## Office of Environment & Heritage

**Re: Northparkes Mine Step Change Project (MP 11\_0060) Publicly Exhibited  
Environmental Assessment**

**Attachment A: Biodiversity****Northparkes Mines Step Change Project  
Environmental Assessment Public Exhibition  
Office of Environment and Heritage Response**

FIGURE 3.8
Vegetation Community Mapping
Proposed Kokoda Offset Site

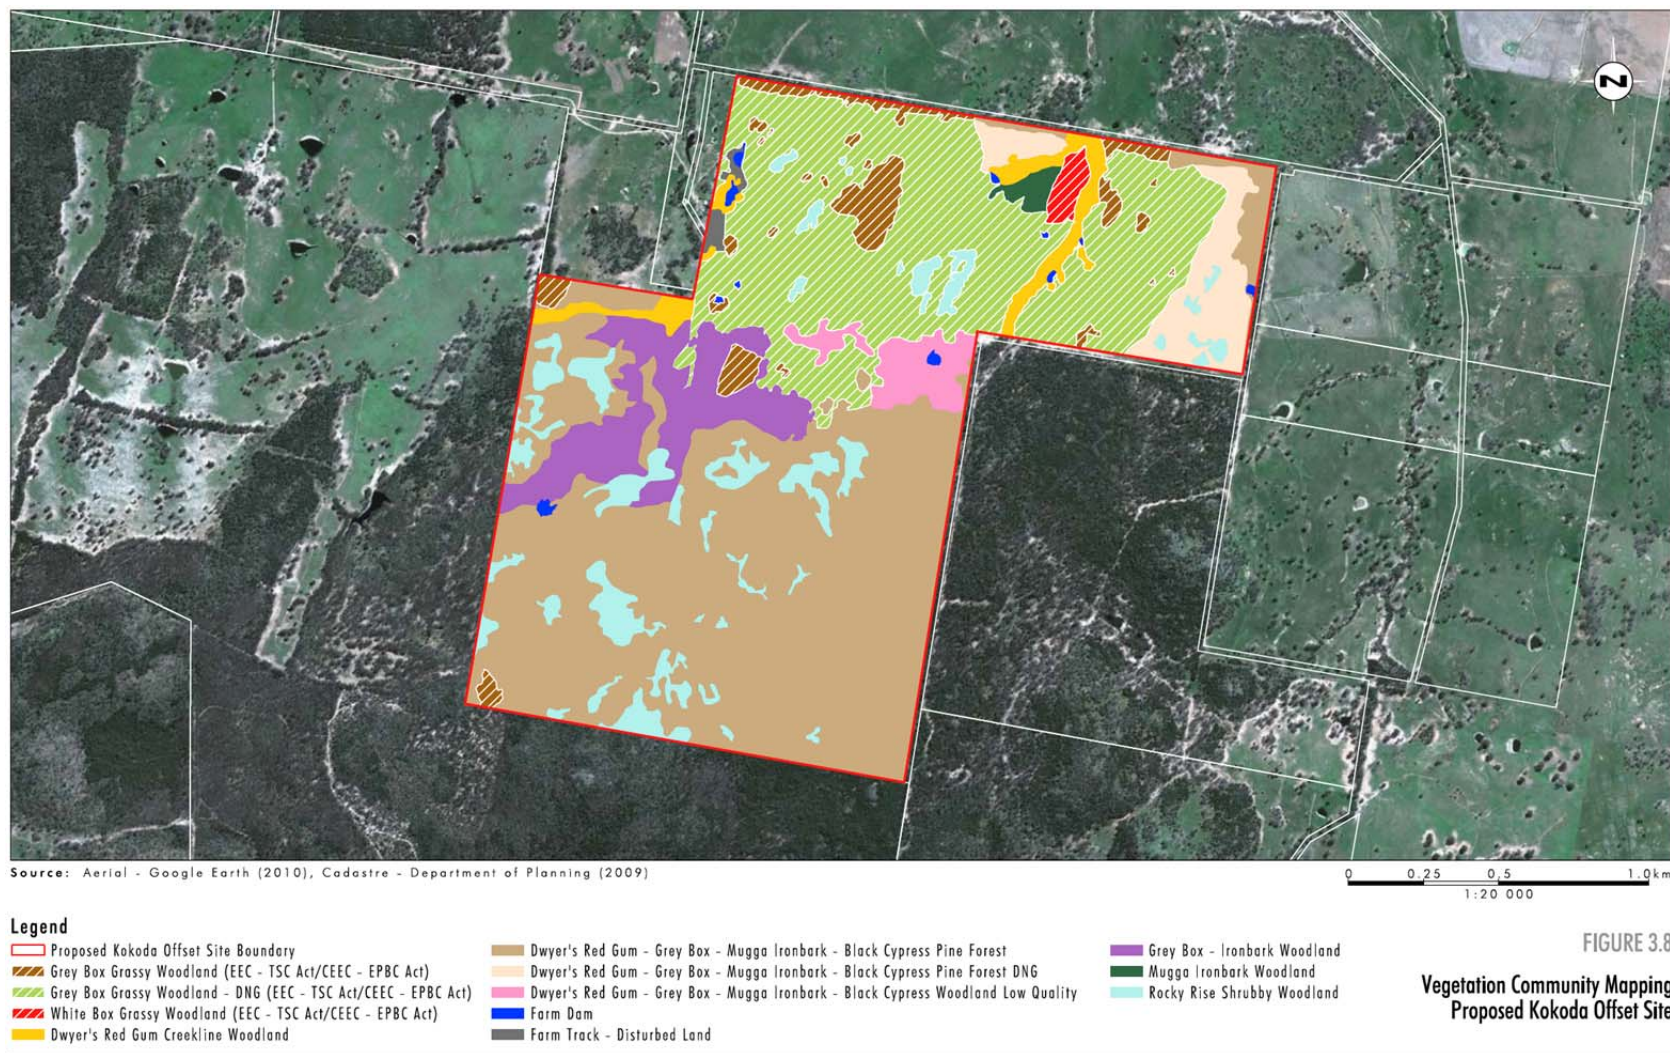
### **3. Restoration of derived native grassland to woodland at the Kokoda offset site requires a clear restoration plan.**

The EA indicates that the Kokoda offset site has areas of derived native grassland that have a natural recovery potential ranging from poor to high. Section 7.3.4 of the Flora and Fauna Assessment indicates that areas of poor recovery potential will be planted to assist regeneration success. It is acknowledged that the proponent has implemented a successful tree planting program at the Northparkes mine site. However, the proposal to establish an ecological community at Kokoda in a different landscape context raises some concerns. Reconstruction of ecological communities involves high risks and uncertainties for biodiversity outcomes and is generally less preferable than other management strategies, such as enhancing existing habitat.

Principle 7 of the NSW offset policy states that offsets must be enduring. OEH supports the intention of the proponent to develop a Biodiversity Offset Management Plan to detail the planned improvements to the offset site as explained in Section 7.3.4. OEH requests that the plan should include a detailed restoration plan with clear targets and outcomes that will assist in the establishment of an ecologically sustainable Grey Box Grassy Woodland EEC. Targets should be created for ecologically appropriate time periods (eg. 2, 5, 10 years, etc) and the plan should also include contingencies should these outcomes not be achieved.

- 3.1** A Biodiversity Offset Management Plan should be developed for the biodiversity offset strategy. OEH requests input into the development of the plan. The plan should include a detailed restoration plan with clear targets and outcomes that will assist in the establishment of an ecologically sustainable Grey Box Grassy Woodland EEC.
